From: [Downes, Scott G \(DFW\)](#)
To: [Kelly Bacon \(CD\)](#)
Cc: [Jeremy Johnston](#); [Torrey, Elizabeth M \(DFW\)](#)
Subject: RE: SE-22-00002 Cape - Notice of Application
Date: Friday, February 4, 2022 1:10:05 PM

Subject: SE-22-00002 Cape - Notice of Application

Parcel #19162 Driveway Improvement Extents

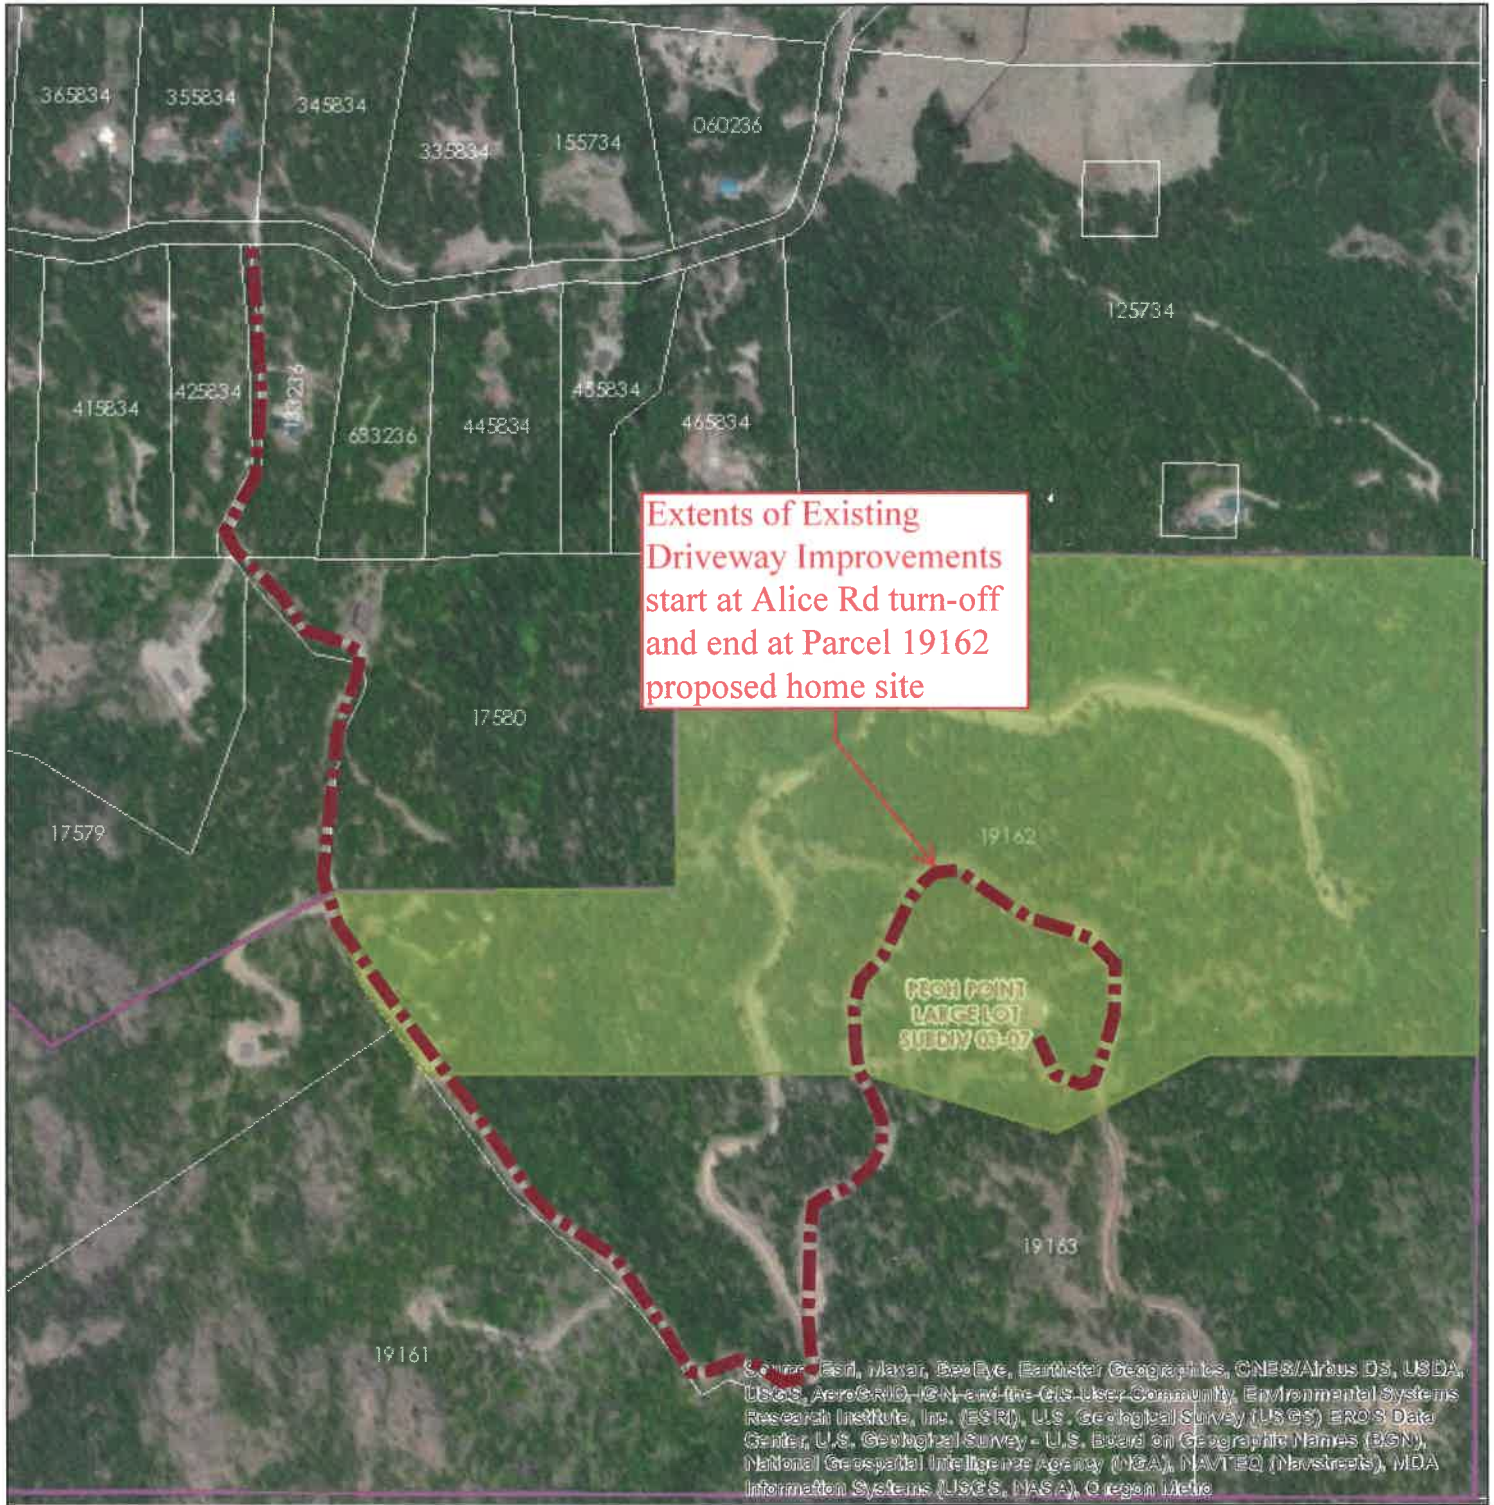
It appears that the driveway improvements are crossing 3 Type 4 streams, these would be Type N (non fish-bearing) streams. WDFW is interested in the work over and around these streams, but could find no details in the application regarding the culvert for proposed work or sizing. If the road is being widened, potentially the culverts would either be getting replaced or extended at these creek locations. WDFW would like to examine the culvert sizing to ensure that we are providing adequately sized culverts to protect downstream habitat which do eventually lead to fish-bearing waters.

If the applicant has information on the proposed culvert work, please have them send that information to me and when its appropriate (probably after the snow melt) I would like to arrange a site visit to look at the water crossings.
